GRADING AND EROSION CONTROL PLANS

SPRINGS AT WATERVIEW

EL PASO COUNTY, STATE OF COLORADO

**TYPICAL WALL SECTION**

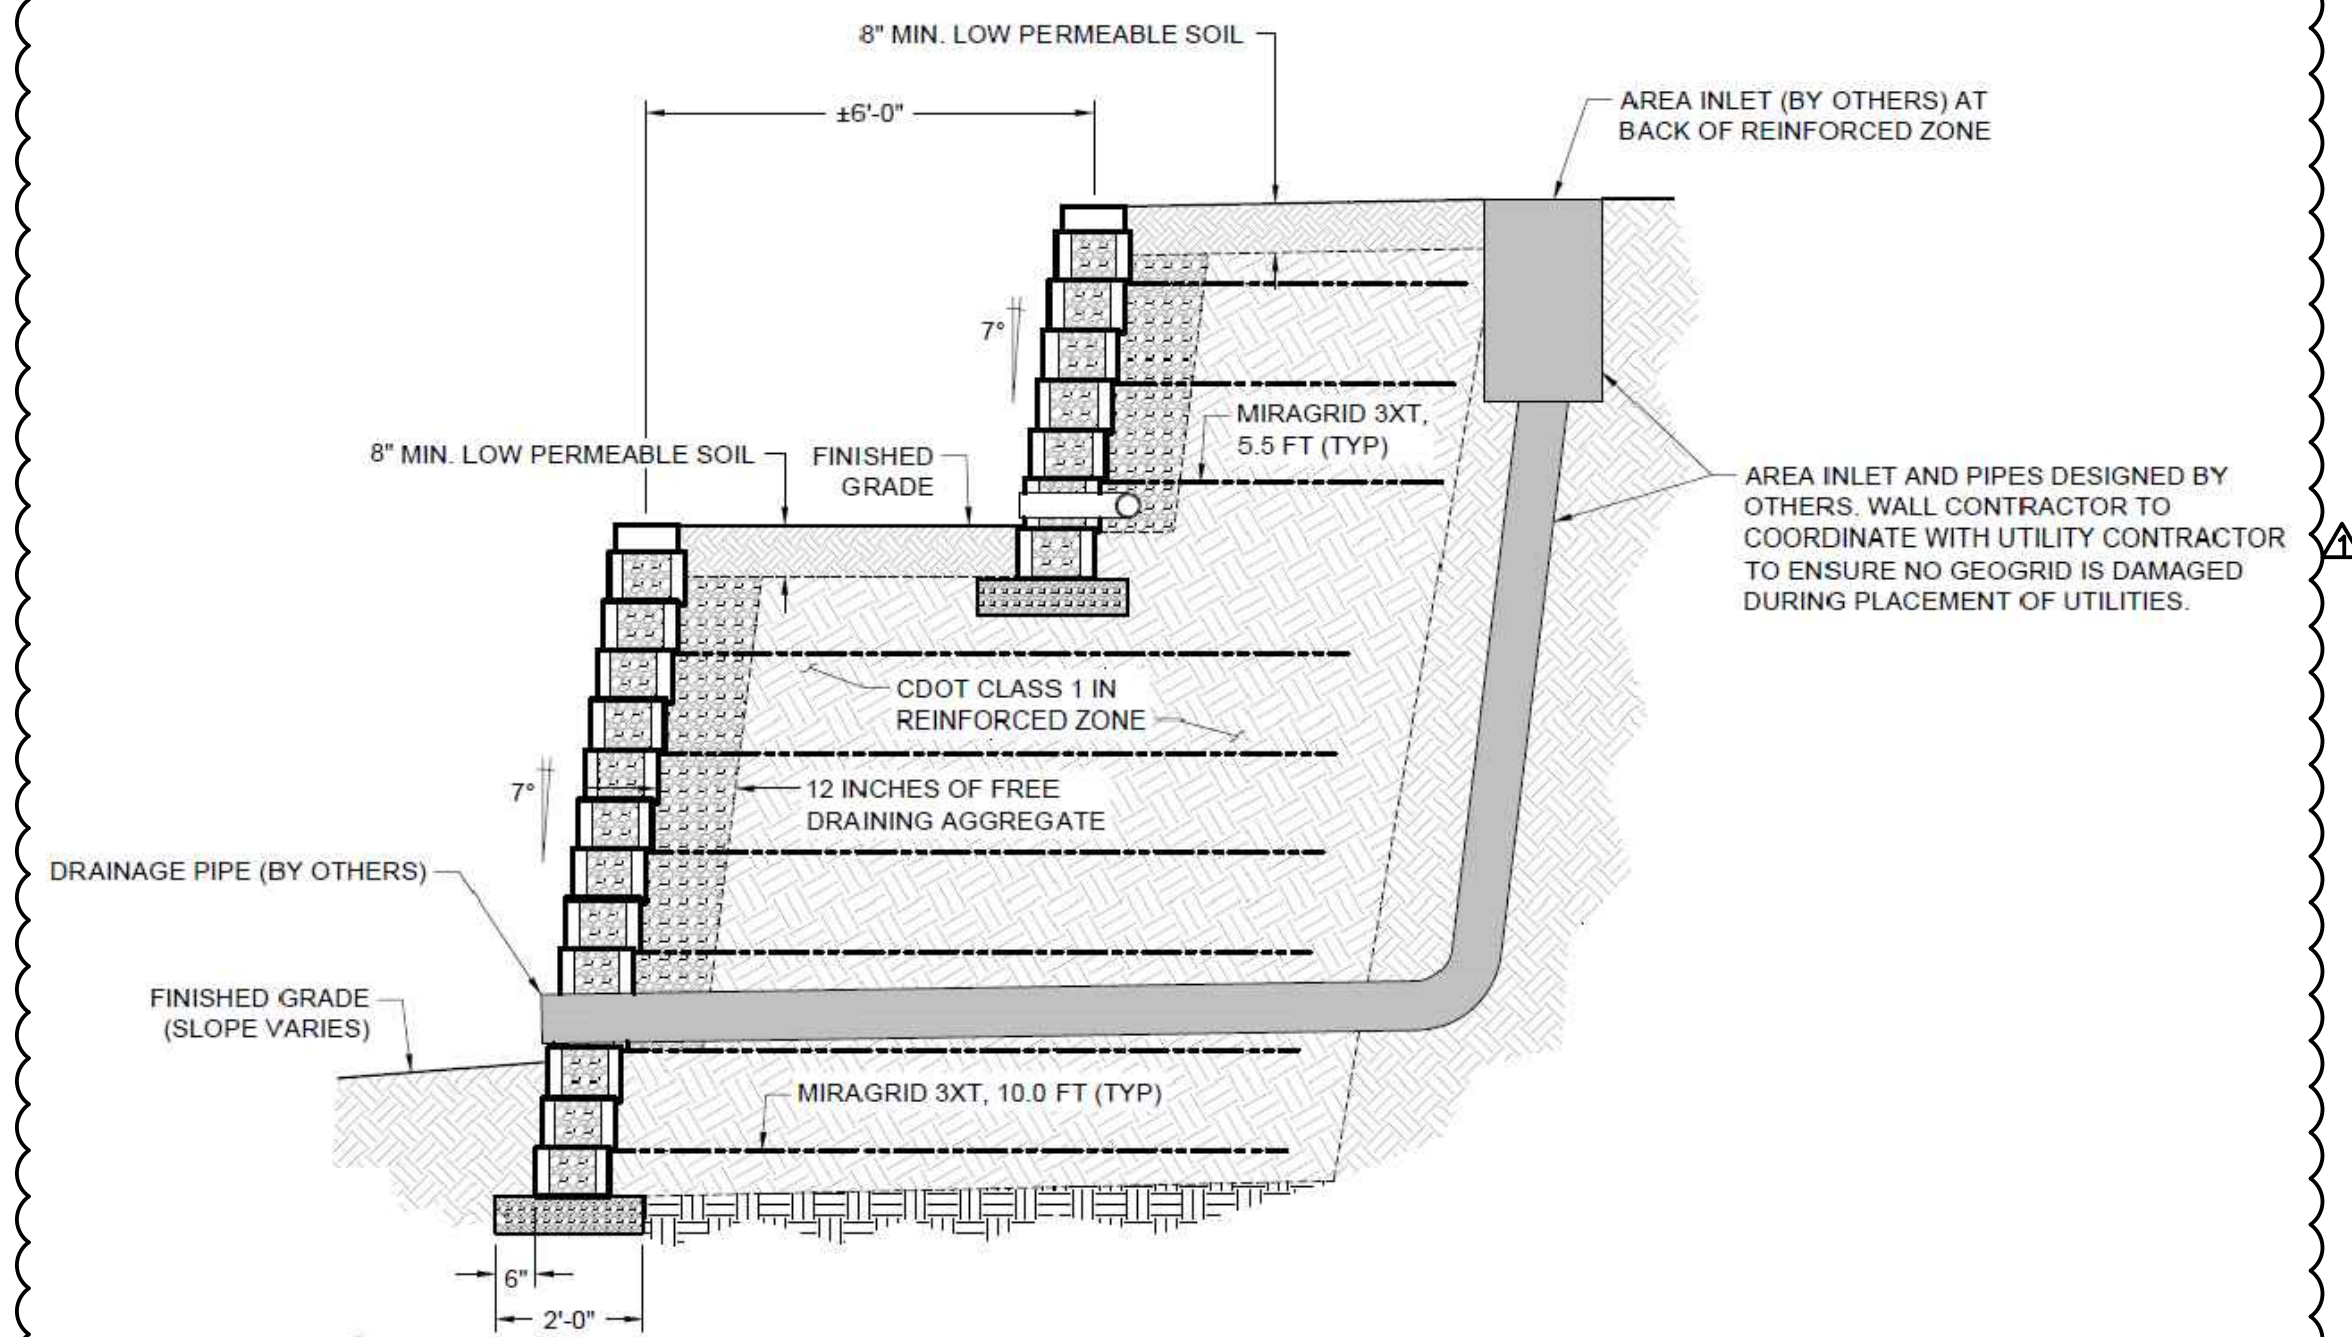
Provide spot elevation on the retaining walls (i.e. grade at top of wall, grade at bottom of wall) and identify the maximum wall heights.

Provide a typical cross section detail of the wall and identify the horizontal distance between the two retaining walls and horizontal distance from the ROW. Verify and note on the plans that retaining wall anchor shall not encroach into the ROW.

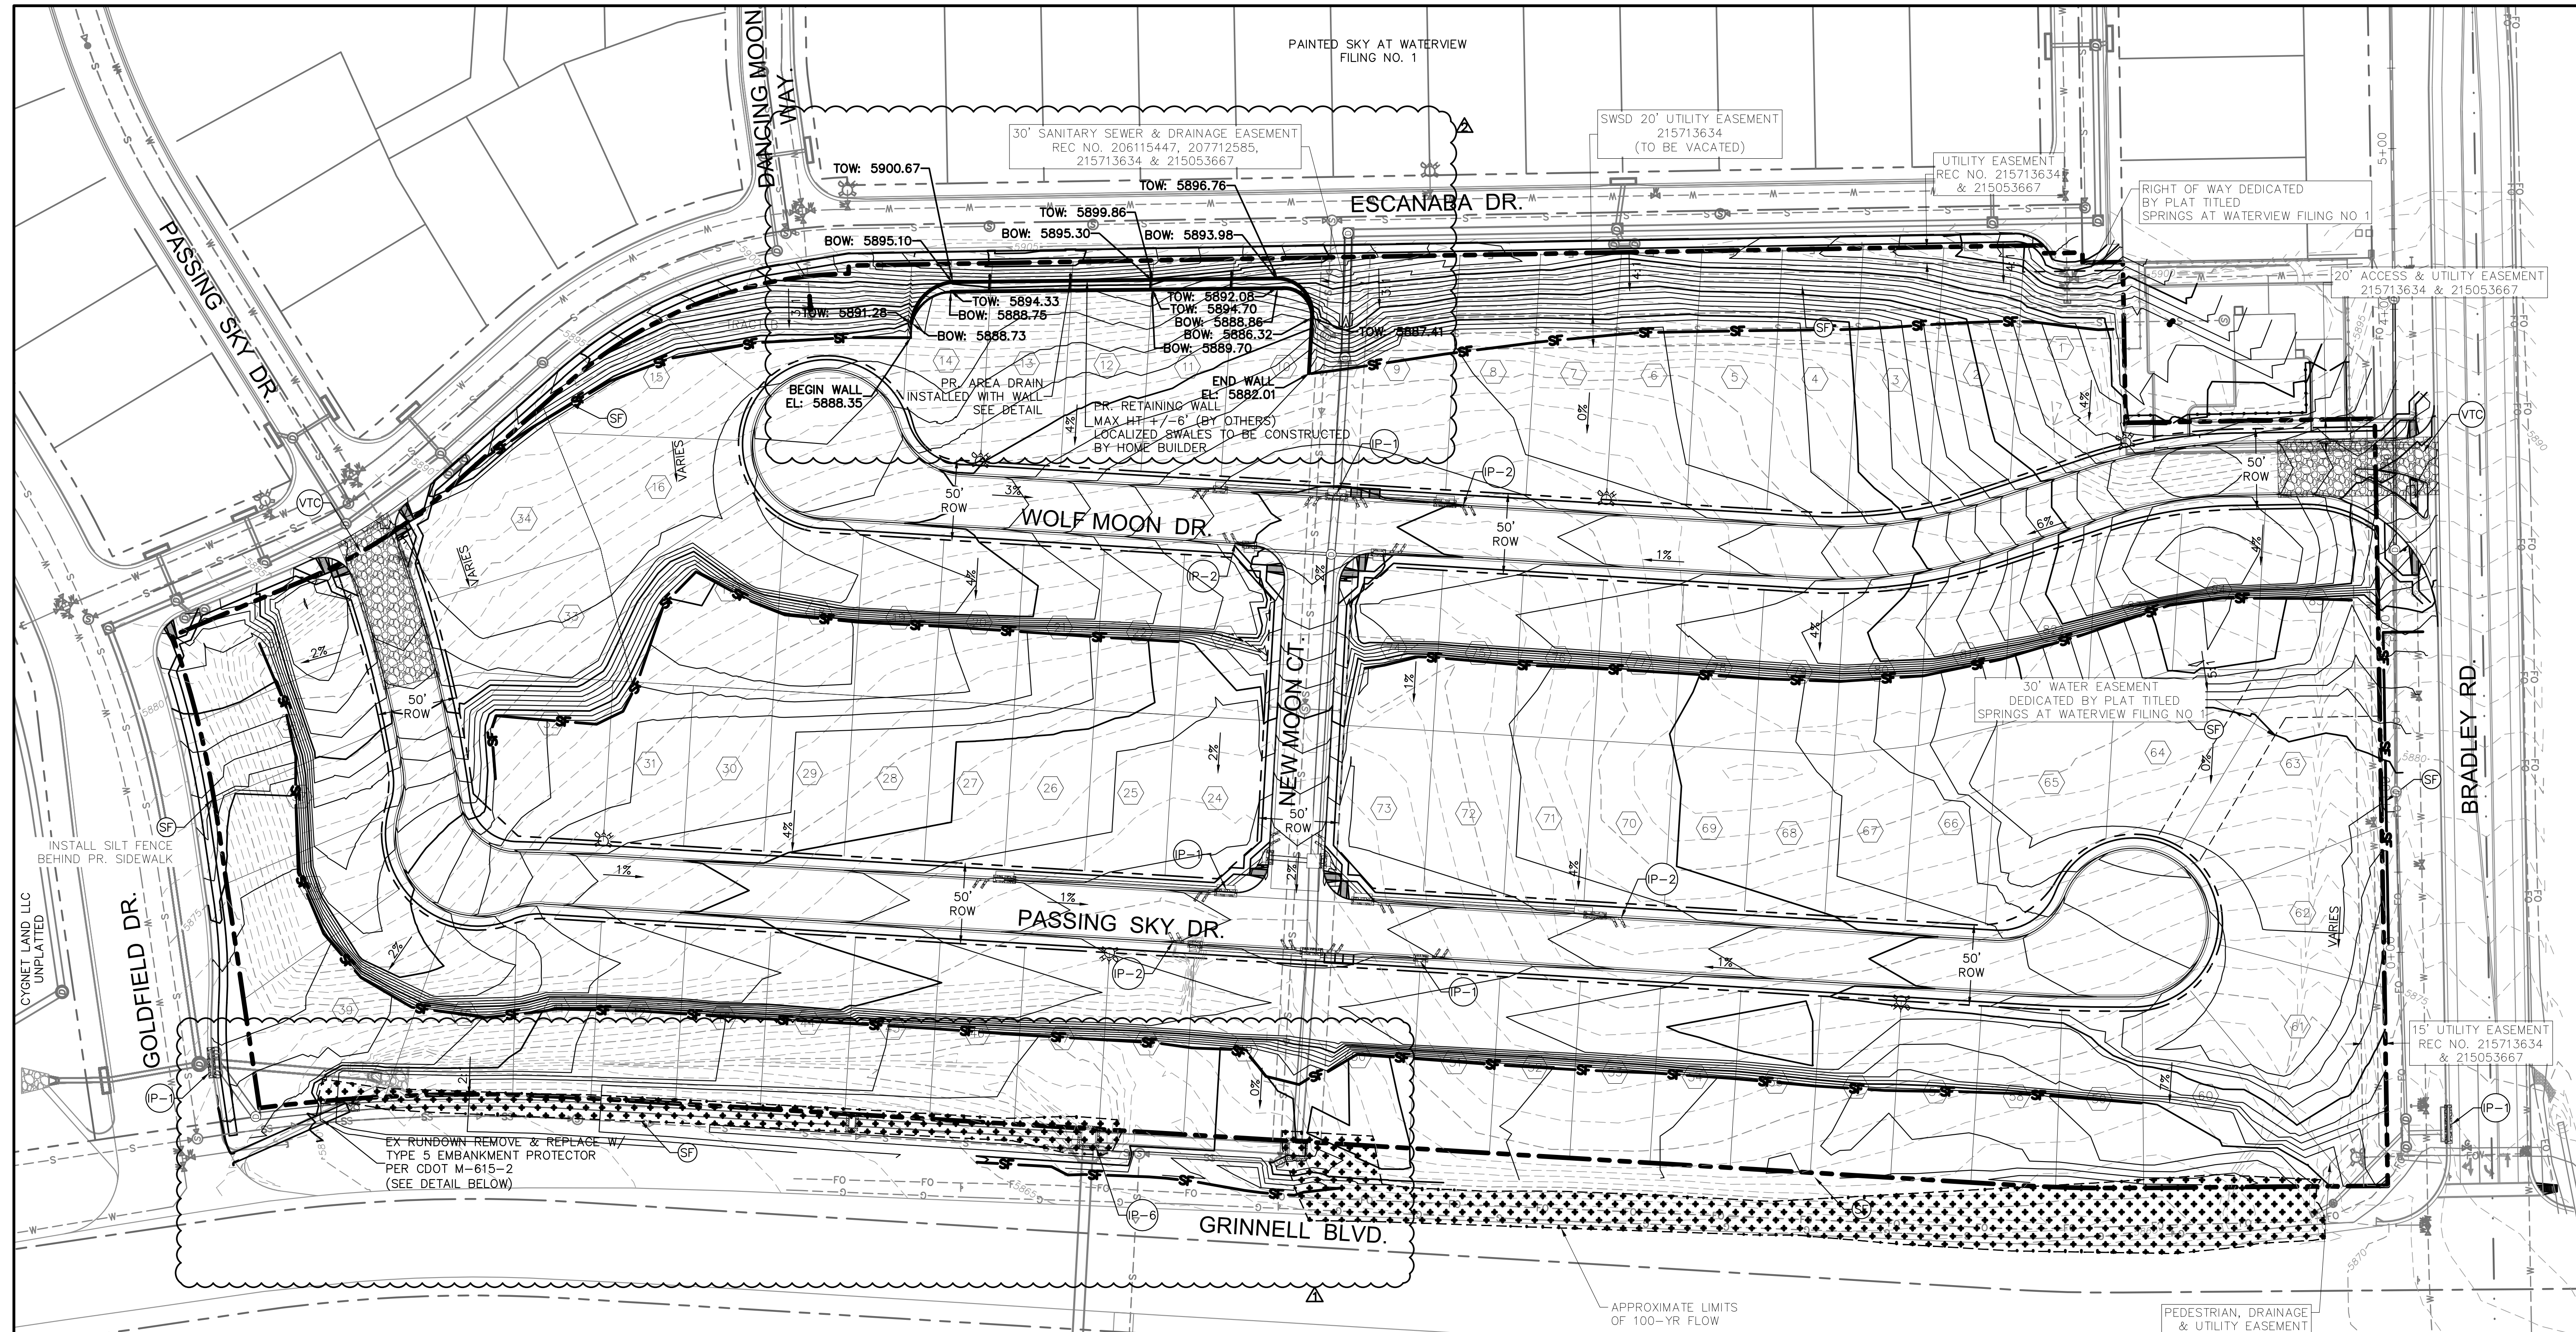
Update this GEC plan contours to reflect the actual proposed design.
